Advice on Modification Report – Redfern Mixed Use Co-living Housing Development – Modification 2 – SSD-32275057

Thank you for your correspondence dated 27 February 2026 inviting the City of Sydney Council (the City) to comment on SSD-32275057 for modifications to the approved development including a reduction to the basement design, upper-level internal design changes, roof top plant and stormwater.

Figure 4 Proposed Basement Plan

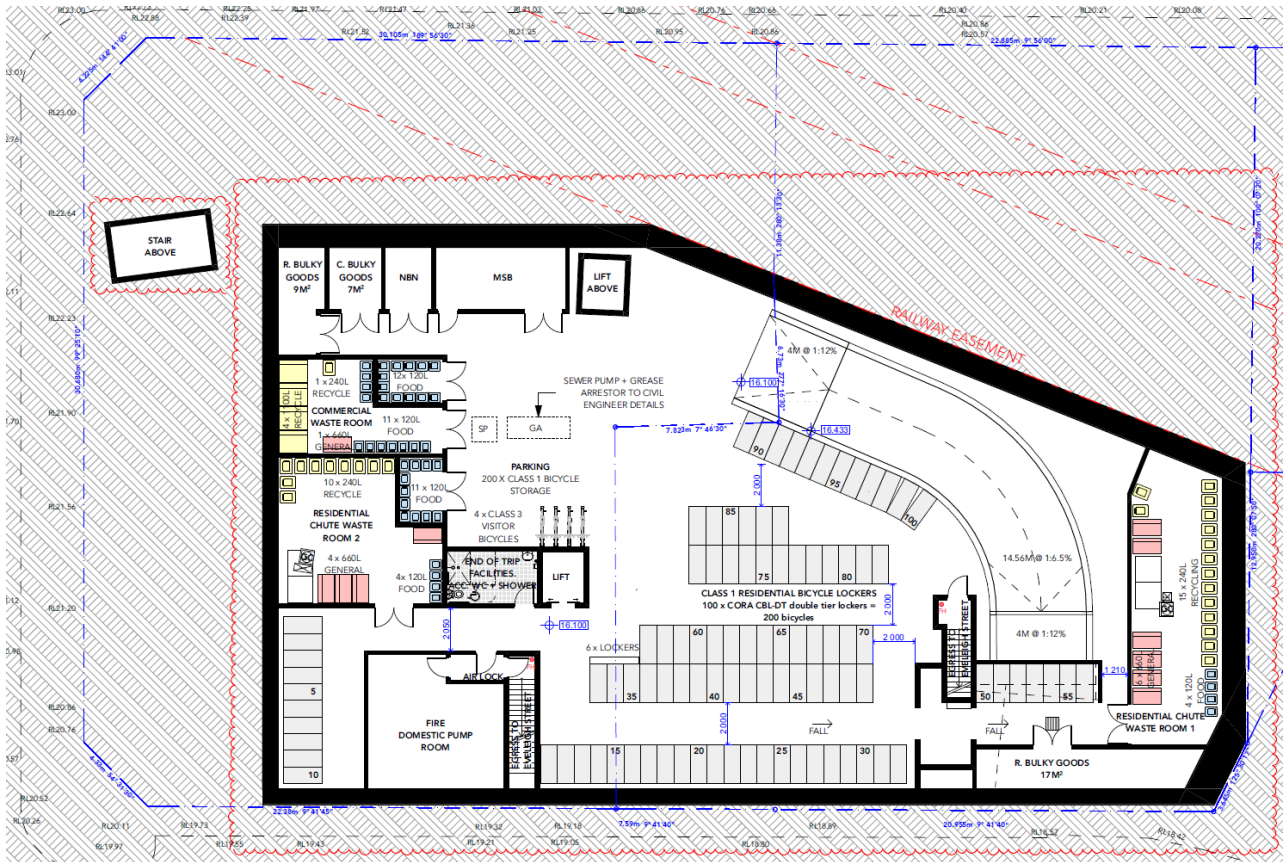
Notwithstanding the SSDA consent, as the application is removing on-site parking from the basement, it is considered that there is opportunity with this modification to reconsider the basement planning and layouts to accommodate a Council garbage collection truck. There are opportunities to review bicycle storage design to facilitate this, and the design of the ramp and basement are capable of modification to be capable of accommodating the minimum truck size of 10.6m.

A rationalisation of the proposed bicycle parking and lockers (as further discussed further below) could allow adequate space for a 10.6m truck within the site and remove the need for private collection for this development.

Notwithstanding the above position of the City, where the Department continues to support a development of this typology that is serviced by private waste collection, then the proposed basement must be modified so that there is a designated (and line marked) loading bay provided. The siting of any loading bay must ensure that it considers safety of other users of the basement (i.e. bicycle riders and pedestrians moving throughout the basement from storing their bikes).

The proposed development includes undersized and inadequate designated waste storage area to service a development of this size when assessed against the City's guidelines.

The bin allocation to be recalculated based on weekly collection/s and demonstrate if the proposed waste storage area is sufficient to accommodate the required bins and infrastructure.

It is recommended the waste storage requirements be recalculated and then subsequently, that the design of the basement be amended to ensure adequate provision of storage rooms is accommodated on site. These areas should be redesigned to meet the City's requirements, a copy of these has been included at Appendix A of this letter.
